THANET FISHERMEN'S ASSOCIATION.

Thanet Extension Offshore Windfarm. Planning Inspectorate-Application by Vattenfall Wind Power Ltd for an Order Granting Development Consent.

ISH 8 Hearing Action Points. Thanet Fishermen's Association representation regarding impact level scoring.

**Figure 12.1a**

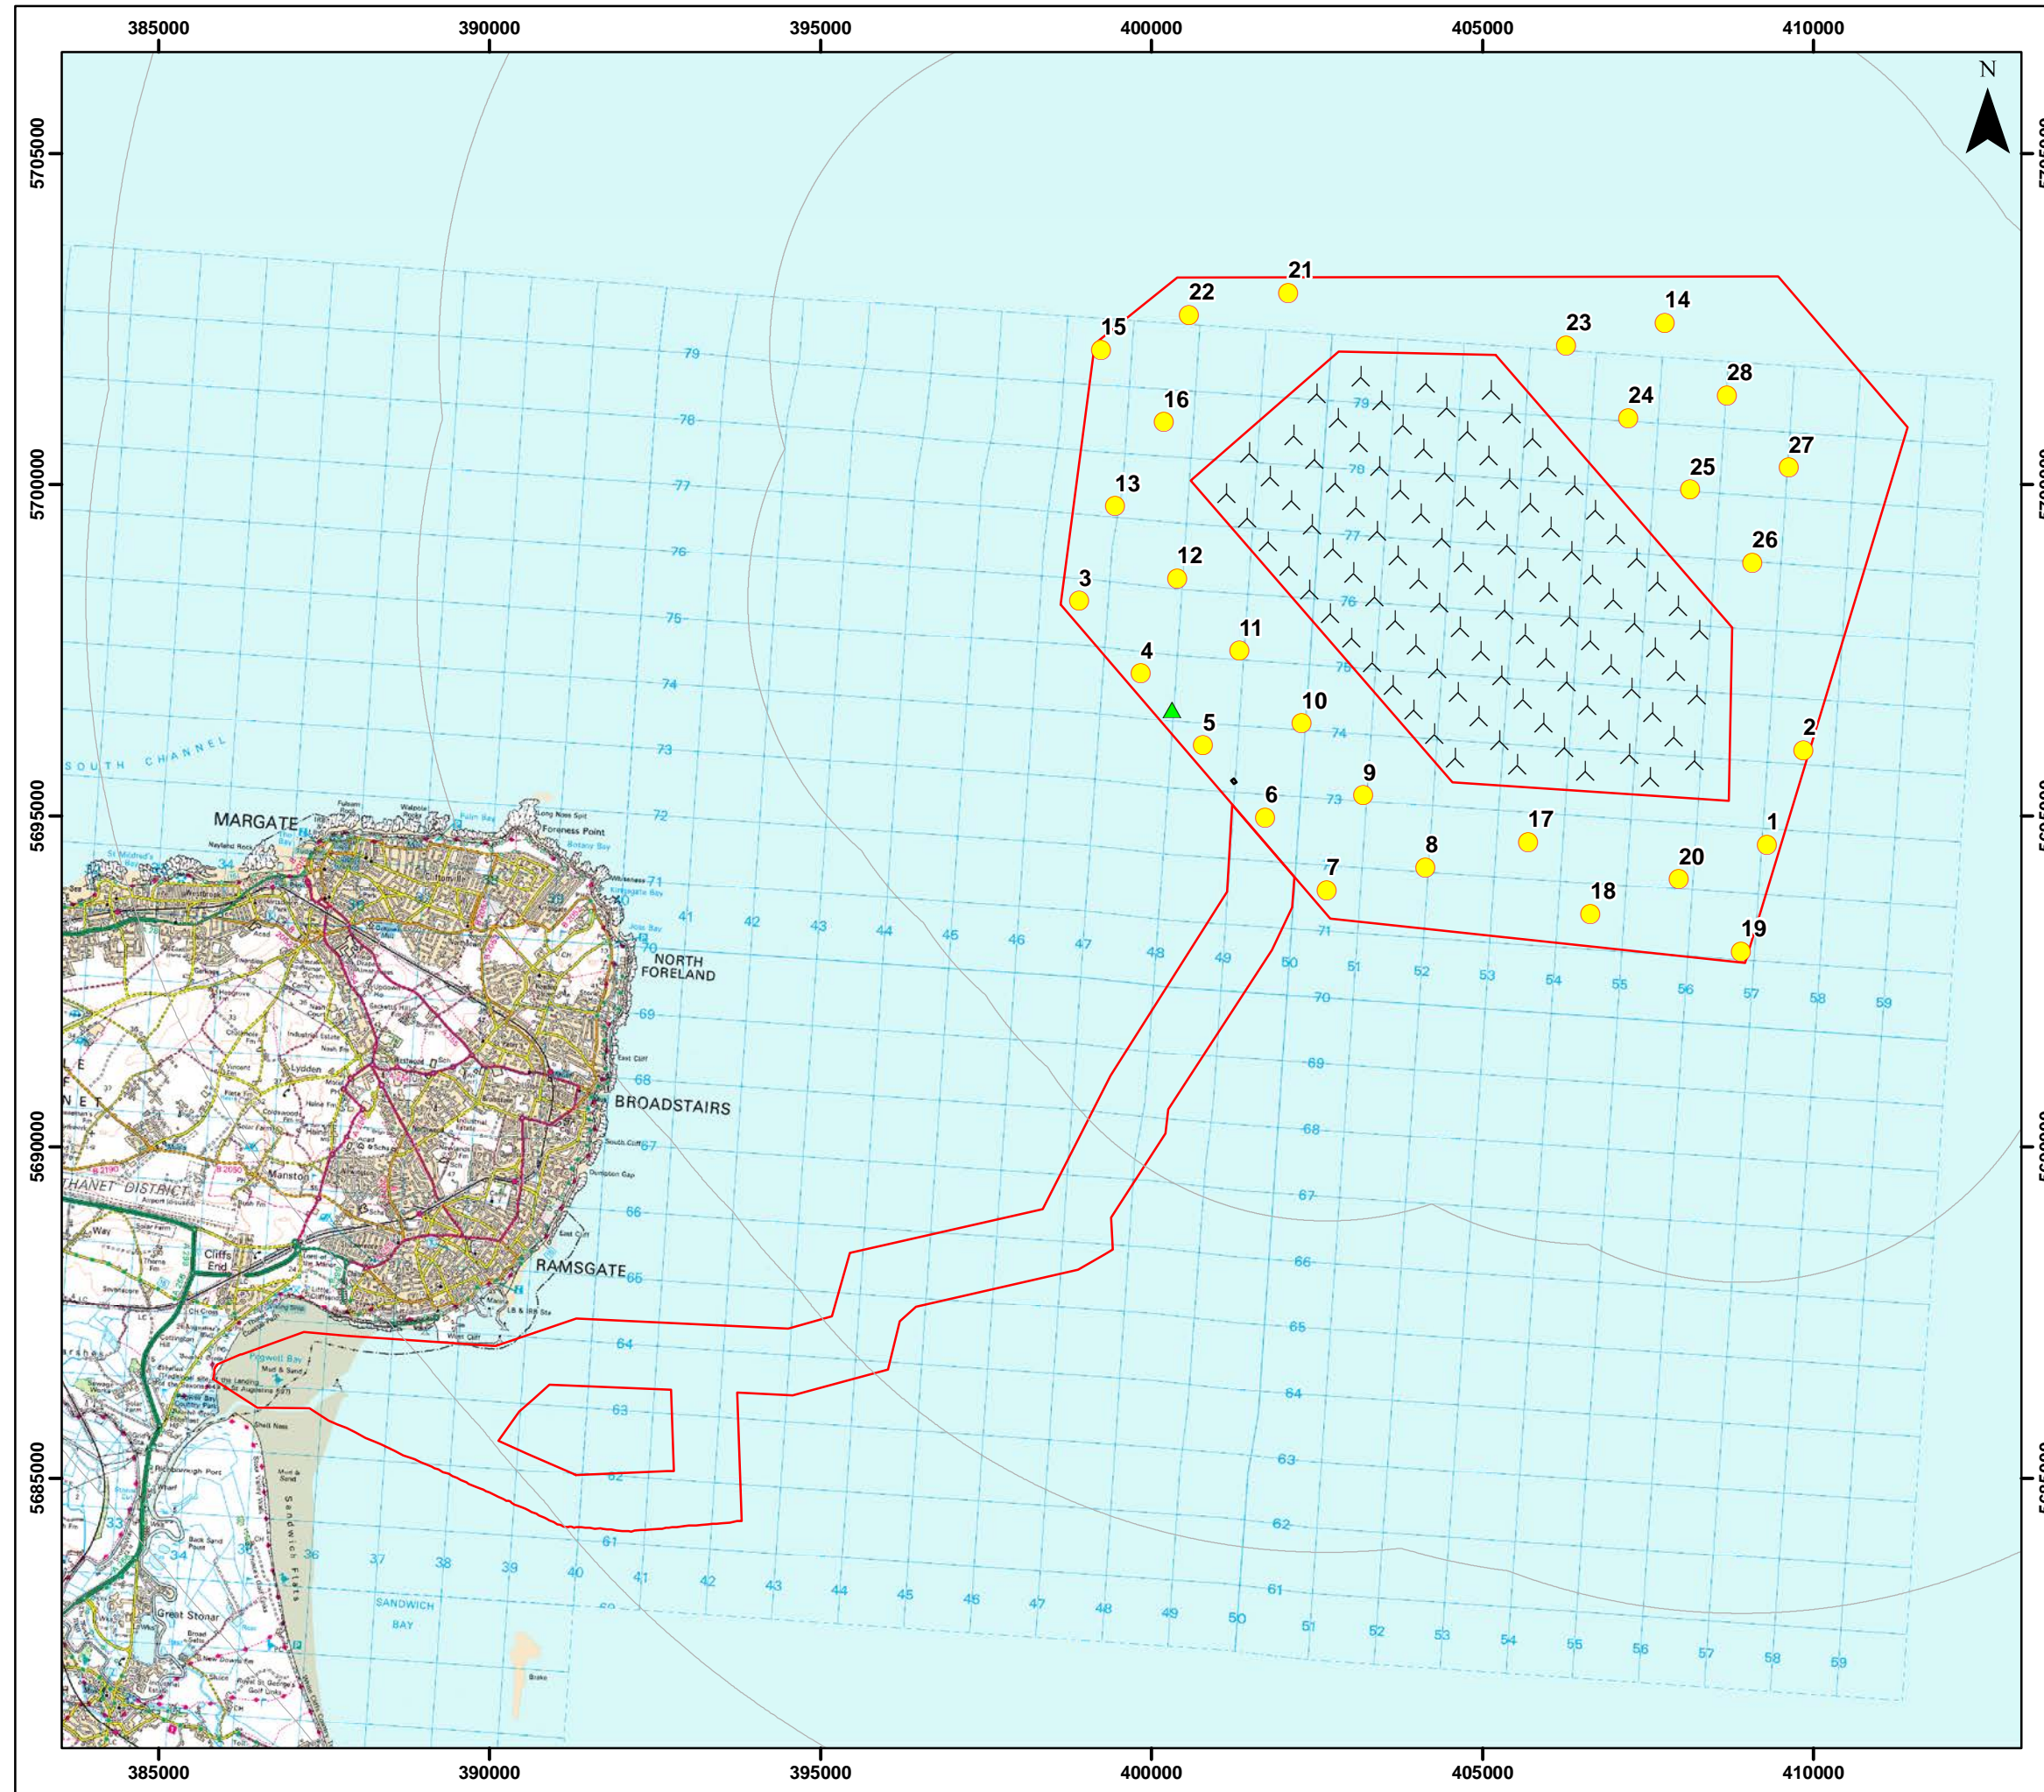
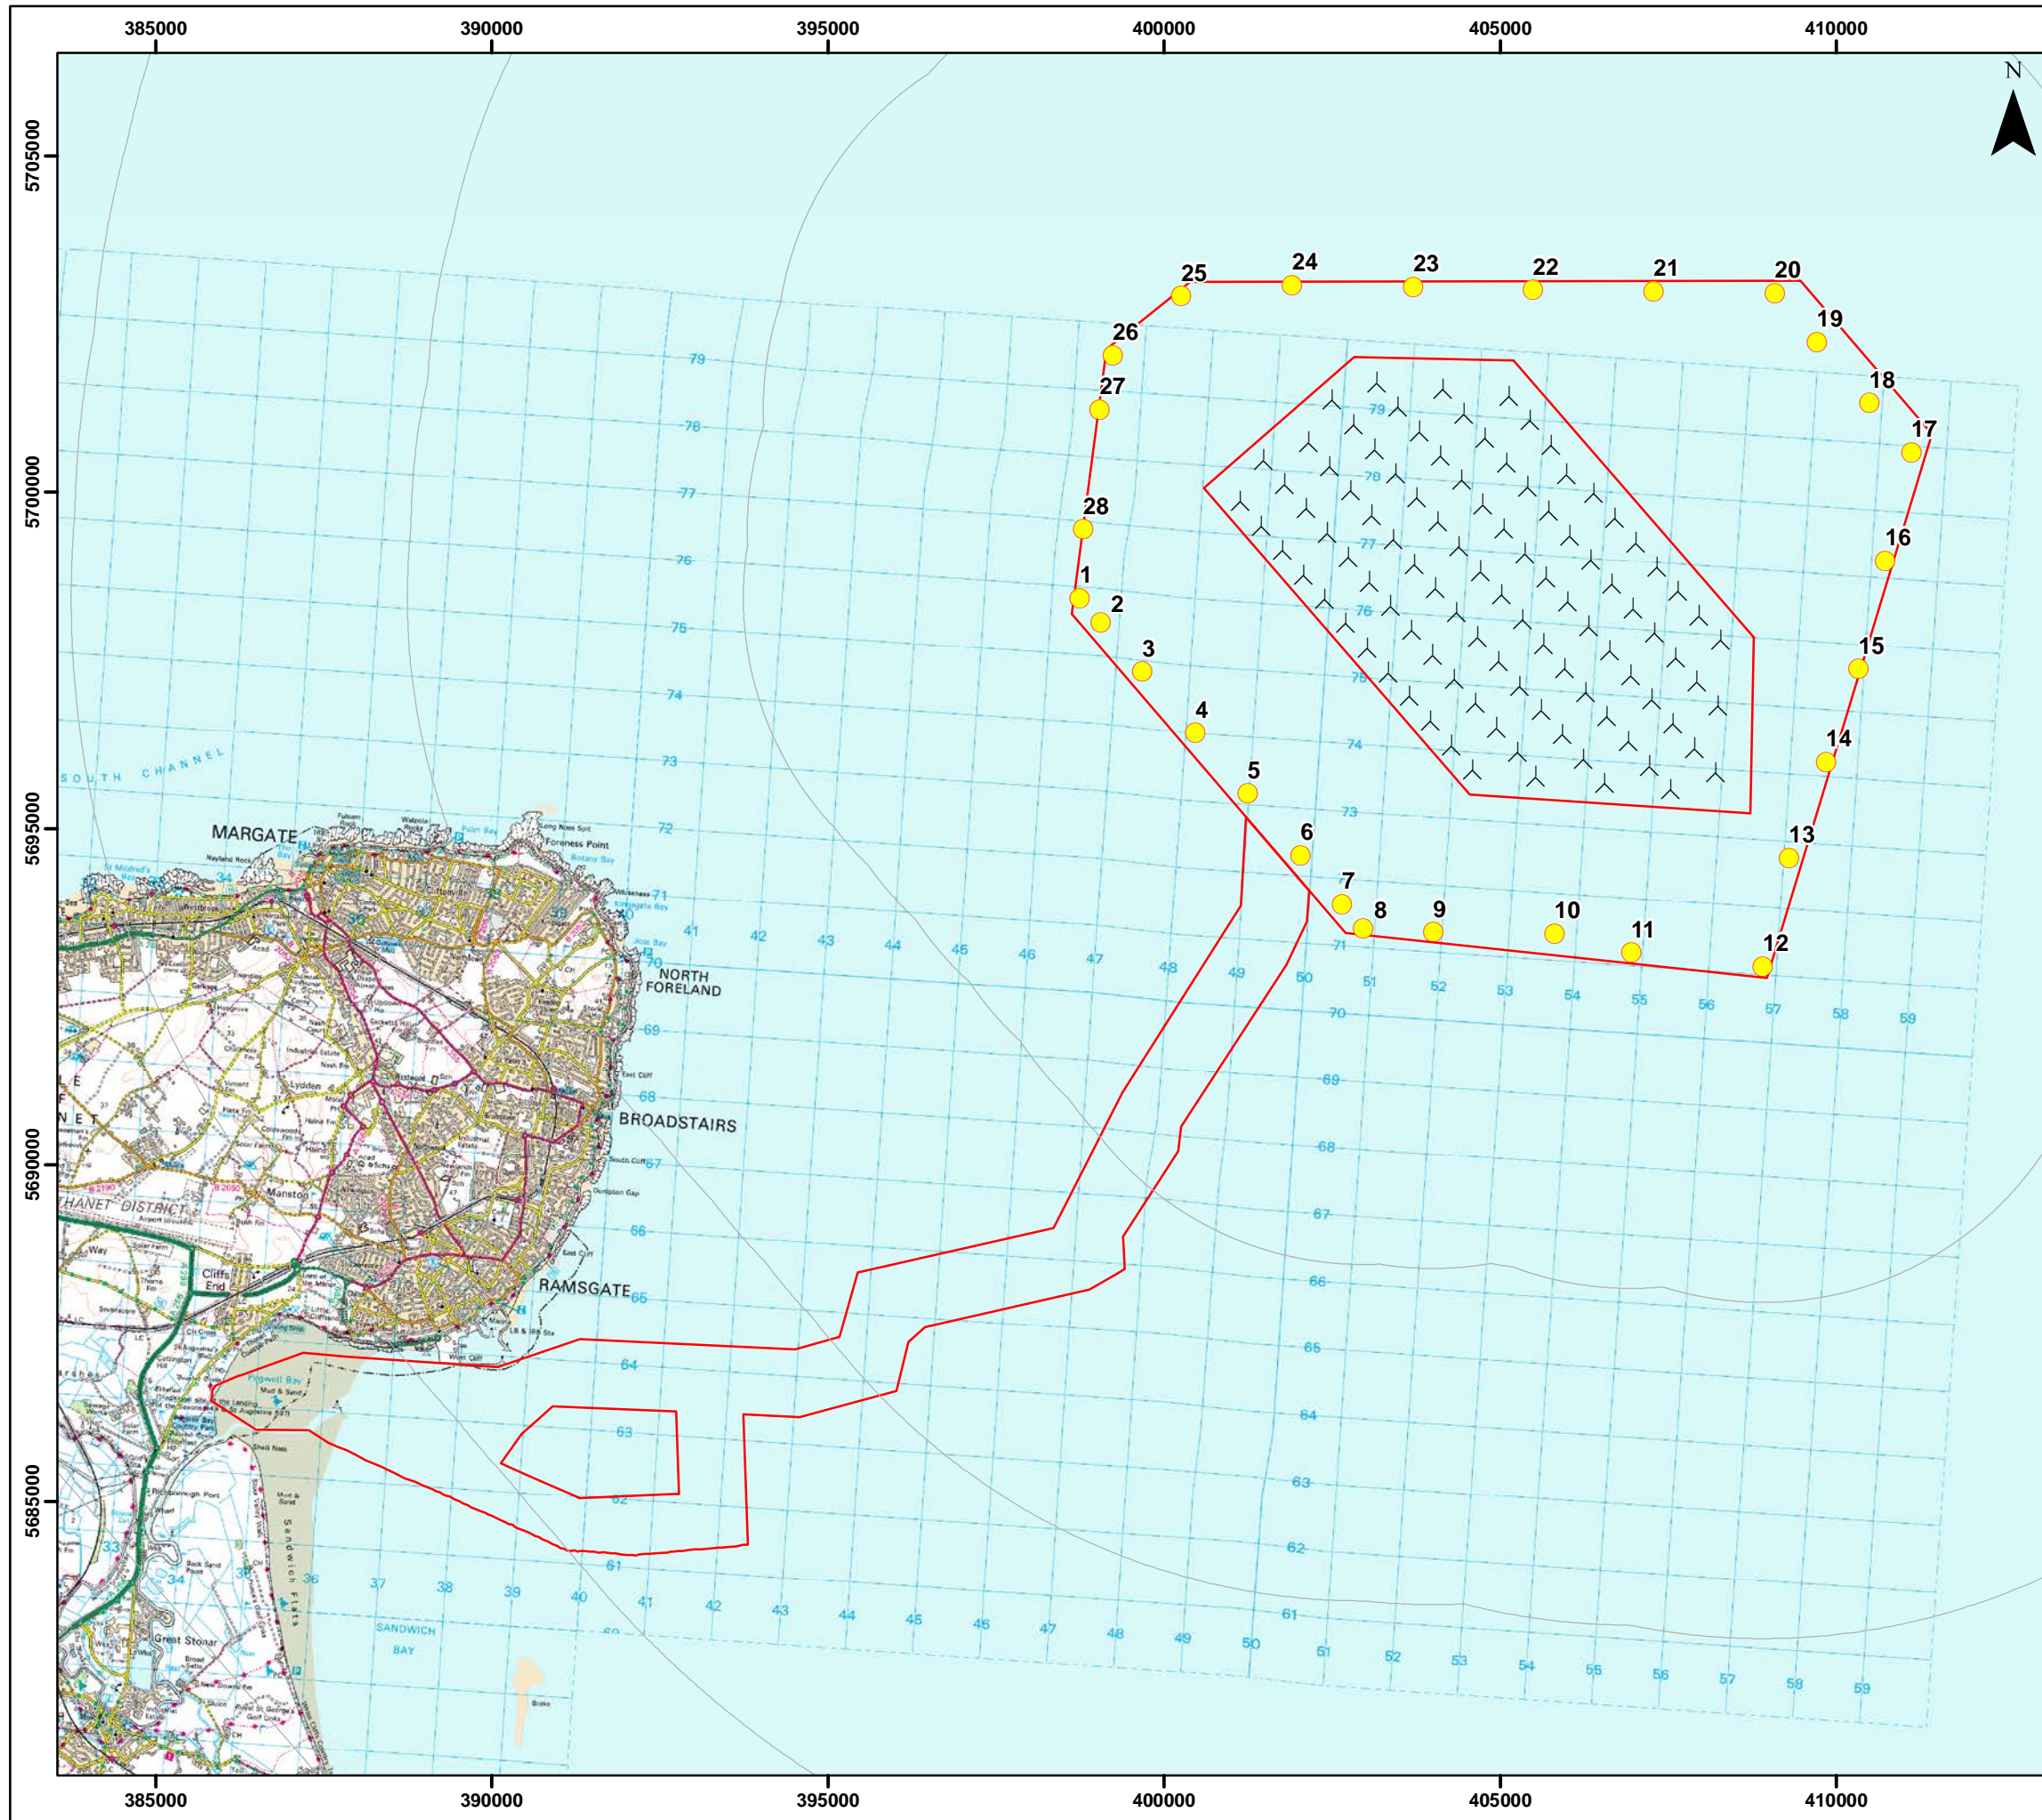
The latest indicative layout, Annex A to Appendix 3 of deadline 4b submission figure 12.1a SEZ, shows that both potting areas within the RLB will have monopiles placed within them. This means that when the potters return after construction, they will not be able to return the same numbers of pots to the ground due to the footprint of a monopile and safety zone, an approximate loss of 9000 square meters per monopile (based upon a 50m safety zone). Until a definitive monopile position is clear, it is hard to estimate how many pots will be displaced but these will either be added to the pots along the shoreline, and to the smaller areas, or will no longer be worked at all.

Figure 9 above shows the Drift ground used by Fishing vessel Defiant during June 2017, as discussed at ISH 6. The Defiant consistently fishes these drifts and her [REDACTED] tracks for the year 2017 show her in and around the same area. Approximately 90% of her annual earnings come from this area. The indicative layout prior to the SEZ showed monopiles in the Northern, North Eastern and South Eastern drifts. Since the introduction of the SEZ, the revised indicative monopile layout now shows an increased number of monopiles in all three drift areas.
